Consultation Response from KC, Highways Development Management
2020/91748 adj, Castlegate, Huddersfield
Advertisement Consent for erection of digital advertising screen (within a Conservation Area)
Date Responded: 14/07/20 | Responding Officer: J Turner | Responding Ref: K5-8SW/8

This application seeks advertisement consent for the erection of a digital advertising screen (within a conservation area) adjacent to Castlegate, Huddersfield.

It appears to be a resubmission of application number 2019/91883, which was refused on highway safety grounds following concerns expressed by the Principal Engineer of the Council's Highway Safety team. The comments from this application are repeated below and remain the judgement of Highways DM regarding this scheme:

Title: Sign Location
A62 Castlegate Approach
A62 Castlegate, Huddersfield

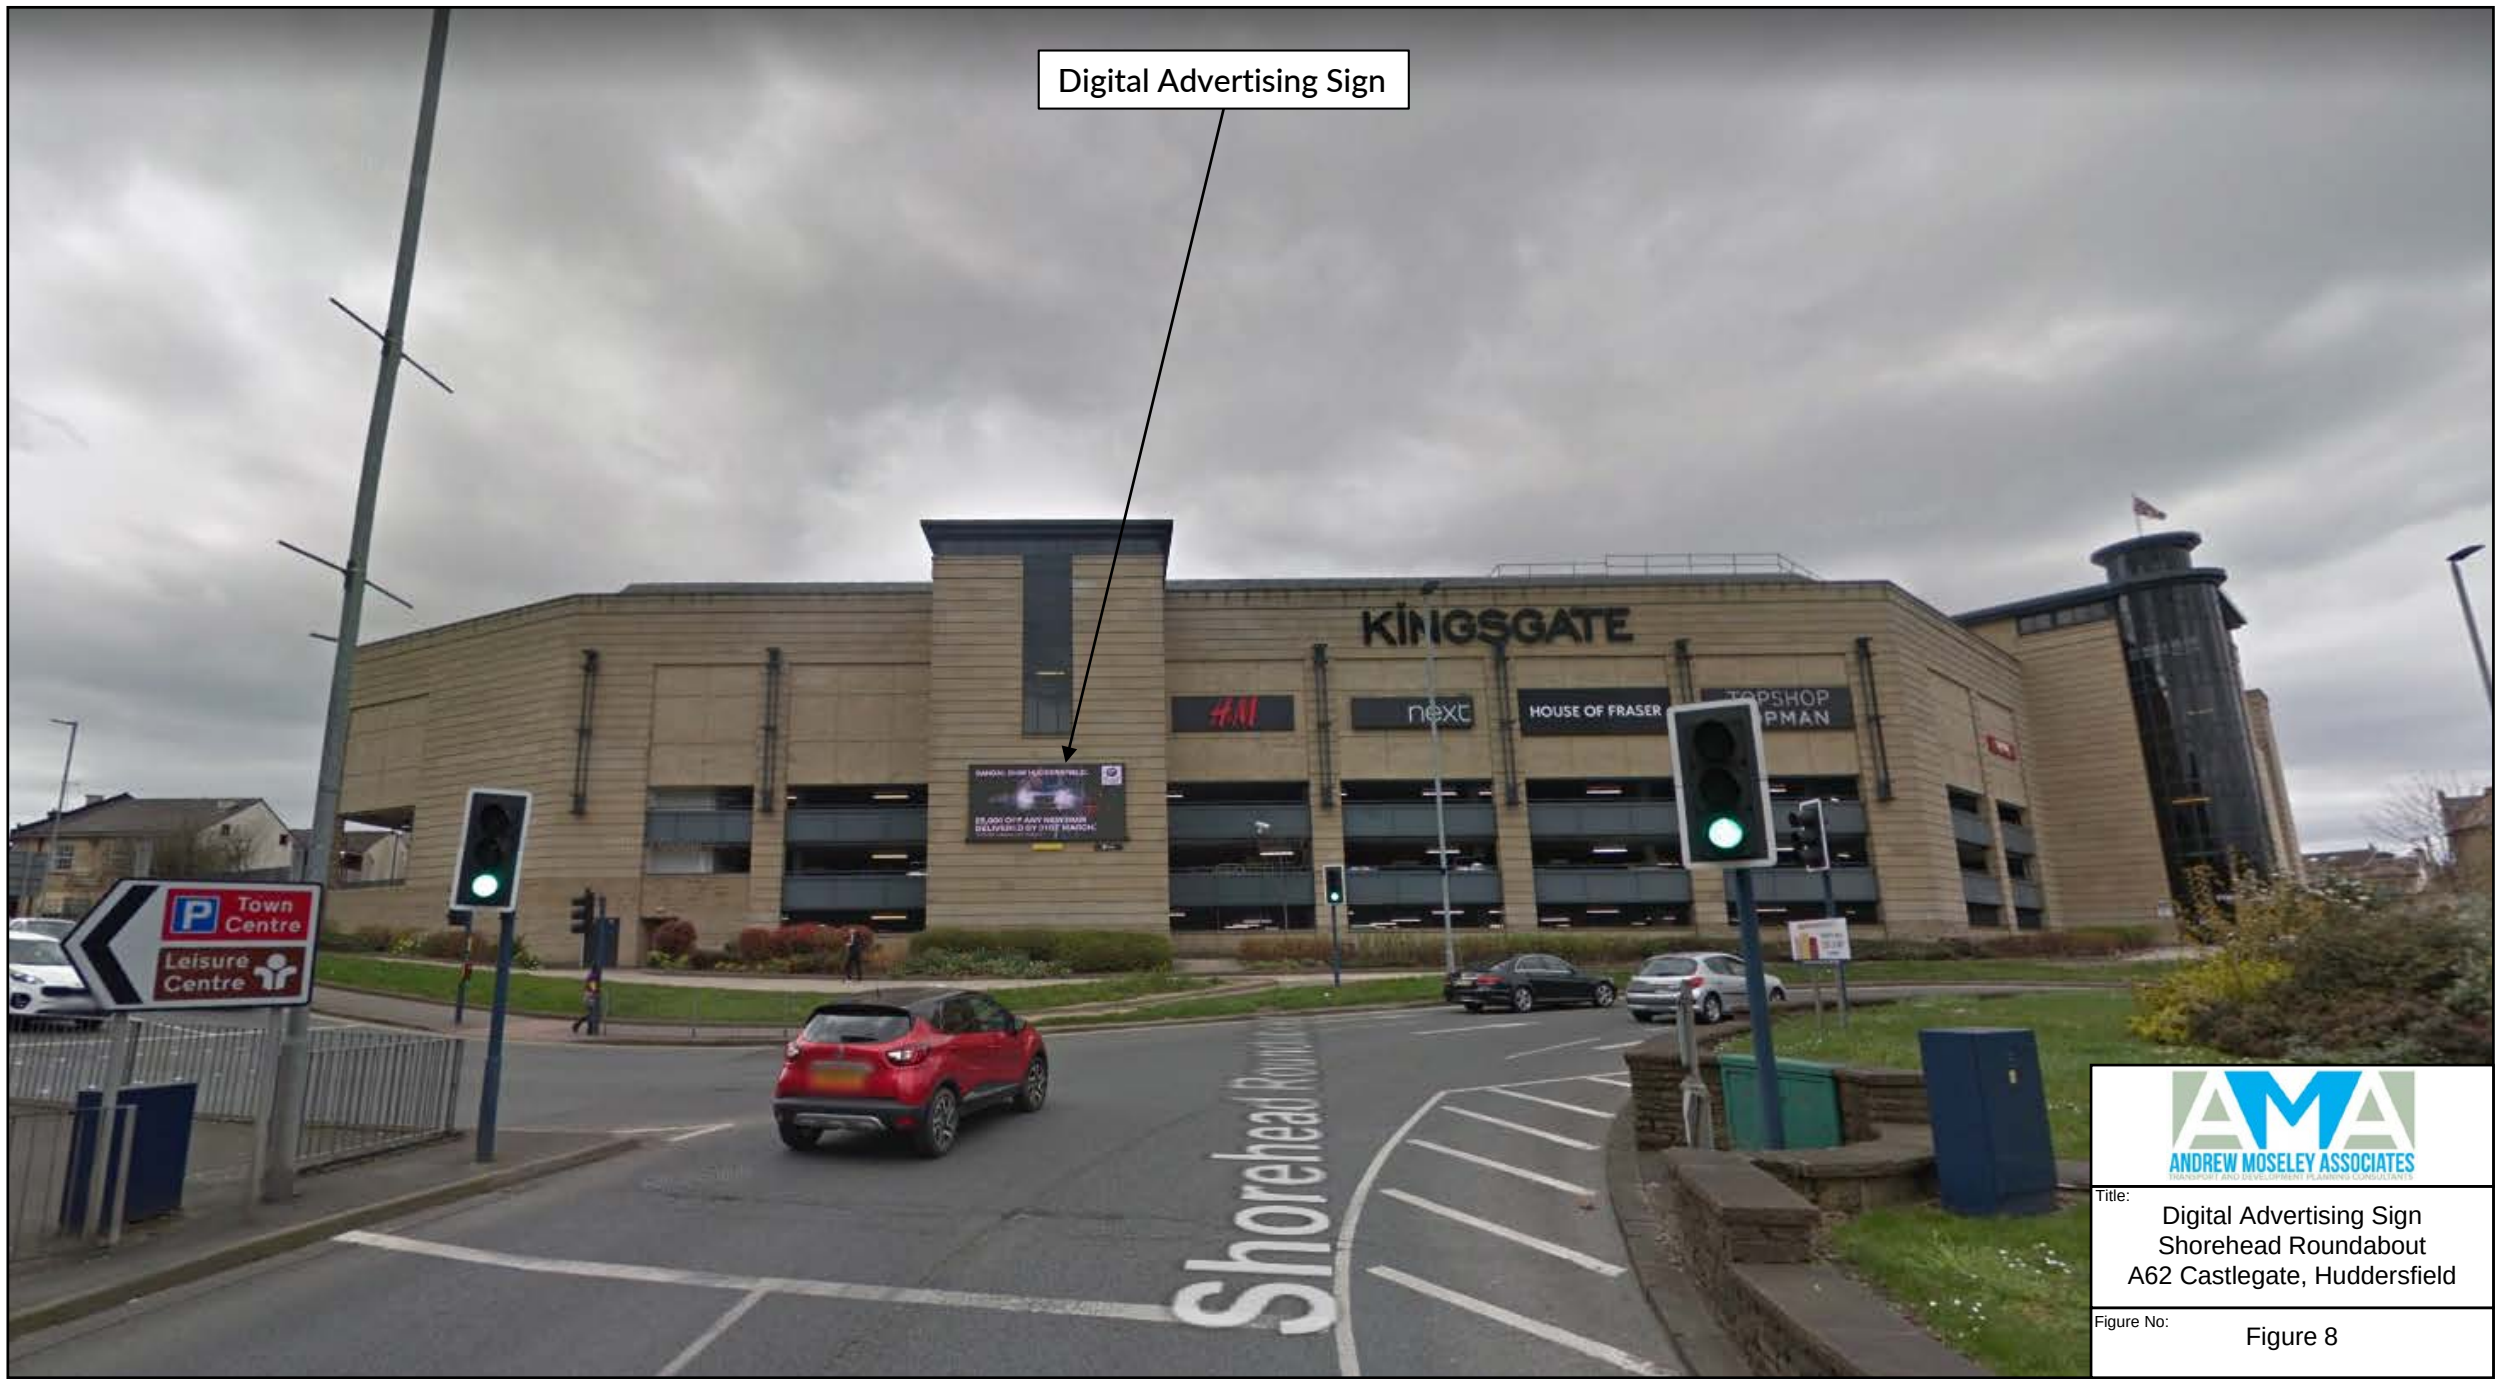
The proposed location on Castlegate is on a major five arm signalised junction on the main town centre ring road, with an abundance of pedestrian crossings and traffic signs in the vicinity. The proposed digital sign would be close to the signals and signs, and would cause the driver to look a significant distance from the signals and signs.

Given this, TfL would expect this location to be given a full safety assessment, and Kirklees Highway Safety department are "opposed to the principle of siting illuminated adverts with varying messages in the vicinity of junctions, traffic signals, pedestrian crossing points etc. Their purpose is essentially to distract road users, and I suspect they are far more successful at doing this than traditional billboard posters. Bearing in mind that at this particular site, motorists will be faced with the sign whilst driving through signals and pedestrian crossing points." They are therefore opposed to the scheme.

It should be noted that there have been six injury accidents reported in the last five years at this

junction, including a serious injury accident in June 2018 directly in front of where the sign would be placed.

As suitability concerns have been raised by those whose remit it is to improve and maintain highway safety, Highways DM can only uphold these concerns and raise objection to the scheme.
